## Appeal Decision

**Appeal Ref: APP/T2350/D/20/3246503**

**3 Loneslack, Chatburn Old Road, Chatburn, BB7 4AB**

- The appeal is made under section 78 of the Town and Country Planning Act 1990 against a refusal to grant planning permission.
  - The appeal is made by Mr David Thornber against the decision of Ribble Valley Borough Council.
  - The application Ref 3/2019/0622, dated 9 July 2019, was refused by notice dated 9 January 2020.
  - The development proposed is described as 'replacement of existing roof, external windows and doors and provision of insulating and cladding to the exterior of the building'.
-

Notes:		
C 2019 05 16 Planning Issue. B 2019 02 16 Dimensions added.		
Rev	Date	Revision
project:		
3 OLD ROAD CHATBURN		
client:		
MR & MRS THORNER		
drawing title:		
ELEVATIONS PROPOSED		
scale:		
1:100 @ A3		
drawn:		
EW		
date:		
2019 05 12		
drg. no.		
1901-02-01		C

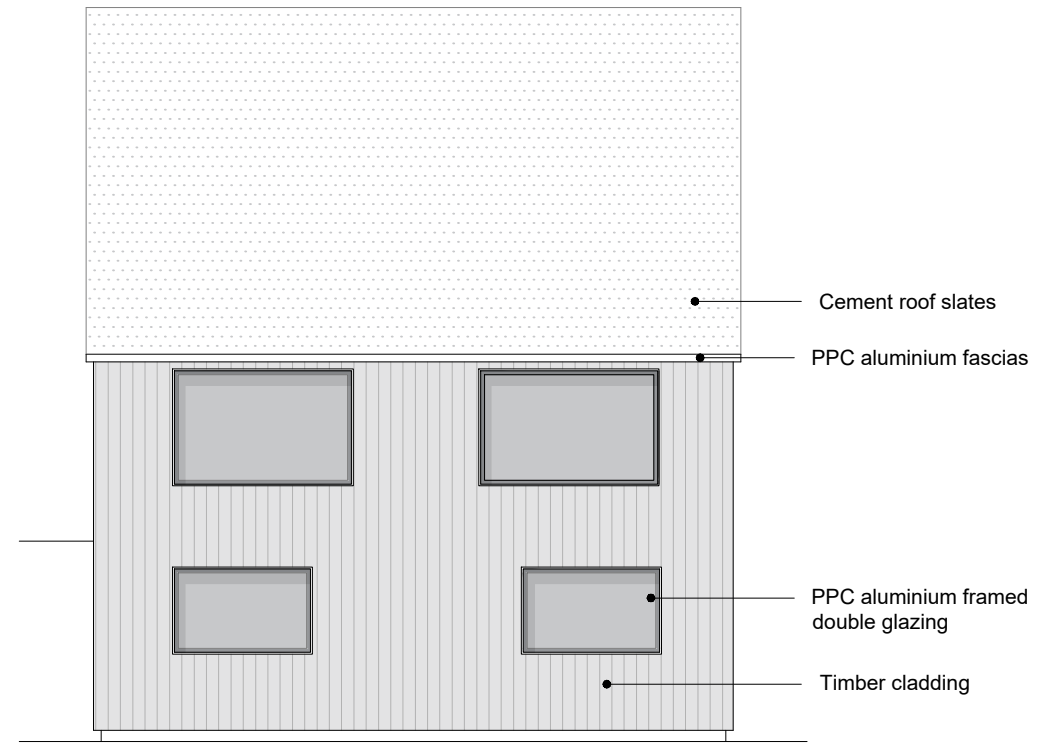
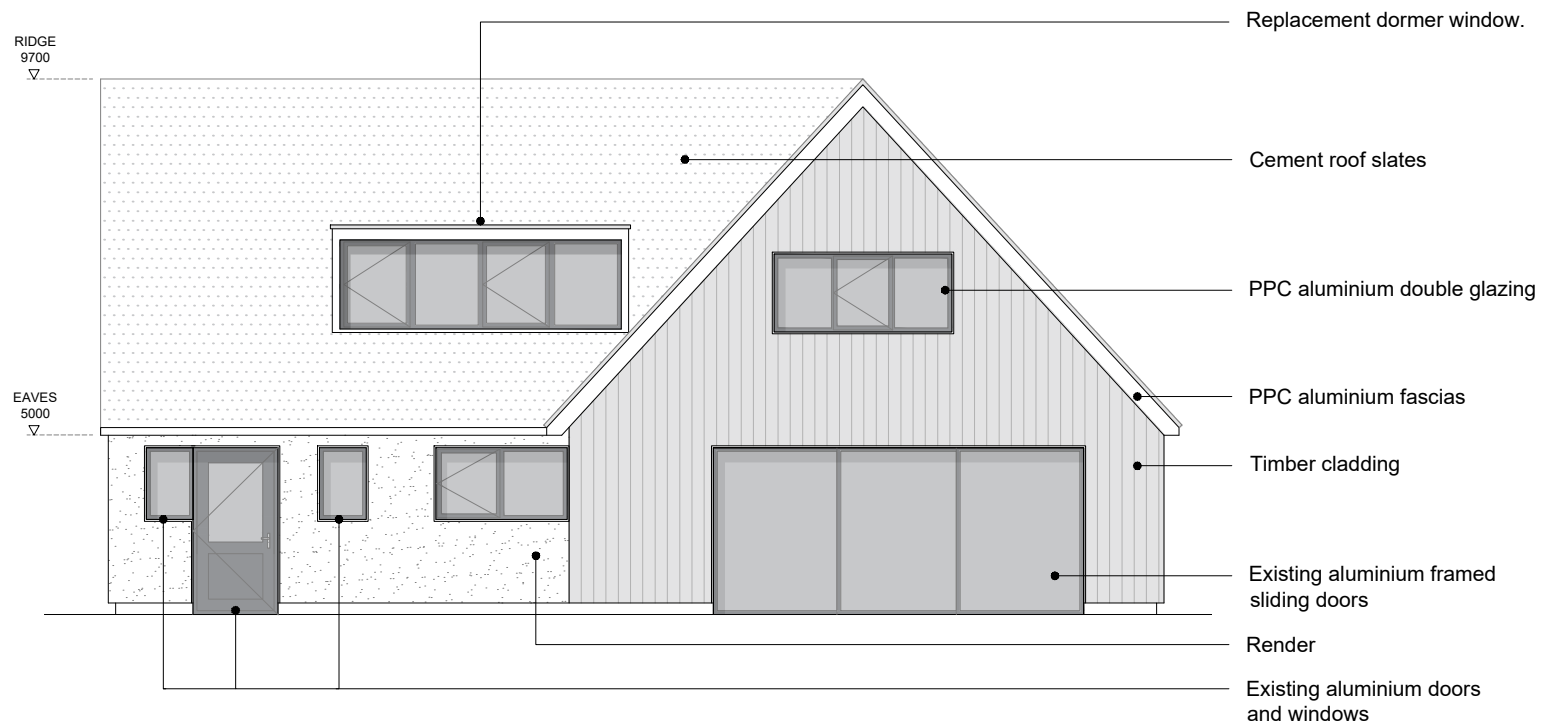
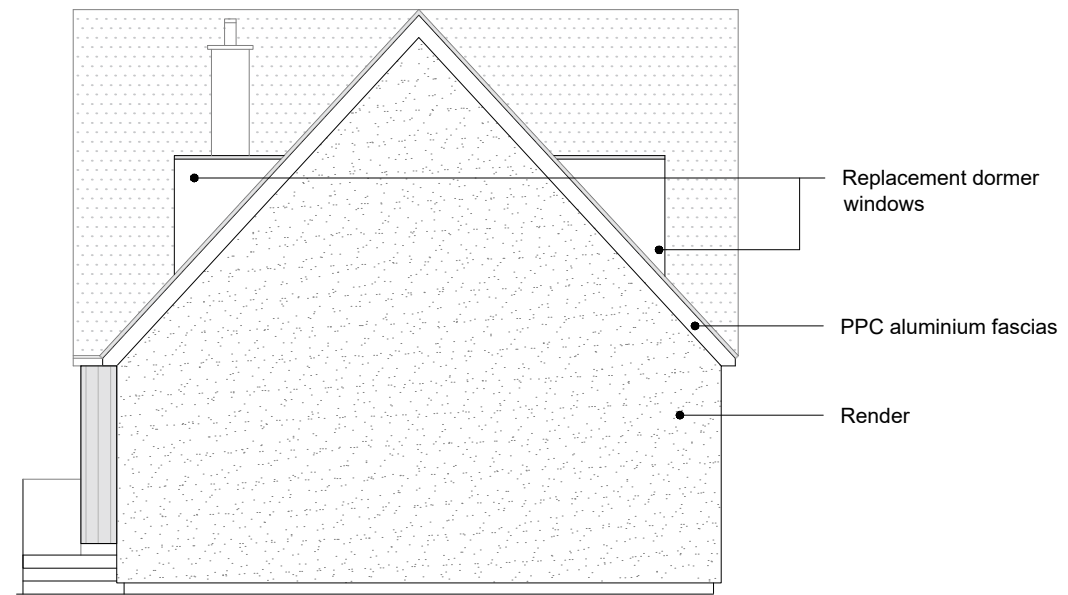
8. The proposal would involve the installation of cladding to the front, side and rear elevations of the appeal property. While the silhouette, form and massing of the building would not be affected by this proposal, such cladding would represent the first addition of its kind along this row of properties and as a result the pleasing coherence that currently exists along the front elevations would be lost. Views of the proposal would be particularly prominent when travelling westwards due to extensive use of cladding, the wide, open driveway and the sloping nature of the road. Here it would be experienced alongside the remaining properties in this group, highlighting the incongruous nature of the cladding.

9. As part of the proposal the doors at the appeal property would also be replaced. From the plans submitted this would involve the replacement of the white metal garage door and timber door along the front elevation of the property with a timber garage door with pass door, and a timber front door with glazed side panel. These alterations would serve to further distinguish the property from the neighbouring dwellings, resulting in the appeal property appearing out of place within this group and failing to relate to the surrounding area in this regard.

10. I recognise that timber cladding is often found on properties of similar style dating from the 1970s but the coherence of the group of dwellings as they step up the hillside is a key feature as described above and the sheer extent of cladding proposed, covering the entire three storeys of the bottom half of the property, would be substantially at odds with the established theme. It would give the main façade a monolithic appearance, in contrast current arrangement where render and artificial stone are used to break up the mass of the tall front section.
